RE: Drainage Report for Parcel 2A, Sunport Park (M15/D23) Submitted for Site Development Plan for Building Permit Approval, Engineer's Stamp Dated 3/6/97.

RE: Sunport Park Drainage
DRB Case 97-119

We have been requested by the Aviation Department to review and comment on the Sunport Park Drainage MasterPlan submitted to the City for review. We have reviewed sheet C-2 of the masterplan dated February 25, 1997, and offer the following comments on behalf of the Aviation Department:

Drawing file: M15D023F / Sunport Park Drainage Plan Phase 1 Sheet C2 04.04.1997.pdf

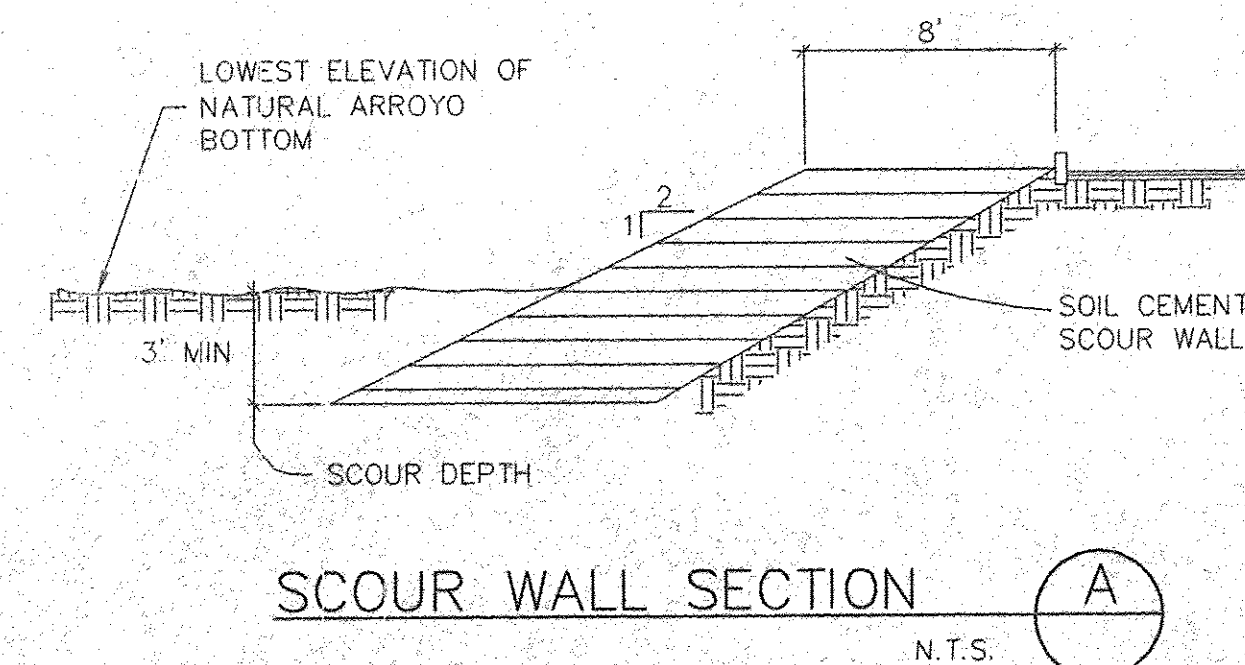
1. The drainage boundaries illustrated on the Phase I portion of the proposed development do not agree with the masterplan prepared by Andrews, Asbury and Robert (AAR). The land treatment shown indicates a 100 percent impervious surface. The Sunport system was designed to accept the basin as shown on that masterplan. The AAR masterplan indicated a land treatment consistent with commercial development with a maximum of 90 percent impervious surface. Undetained flow from the system, shown on the current drawing, may exceed the system capacity.

2. The capacity and structural integrity of the 3-36" RCP crossing at I-25 are of concern due to age and condition. Calculations performed during the preparation of the Sunport Boulevard Drainage Report indicate that the capacity of this structure is approximately 300 cfs. This capacity should not be exceeded in order to protect the improvements constructed in the Sunport Boulevard projects.

3. There is not an easement identified for the 42" outfall pipe from the detention pond.
4. A public detention pond is proposed. Who will be responsible for maintenance?

5. Drop inlets are indicated on the north boundary of Phase I. We assume these are intended to catch surface flows. The finished grading shown indicates a slope of approximately 5% with a cross slope. Will the drop inlets be effective in collecting the surface water prior to reaching the western boundary of the development with the cross slope indicated?
6. Will the proposed public detention pond require permitting through the State Engineer's Office?
7. What provisions will be made for an emergency spillway for the proposed pond?
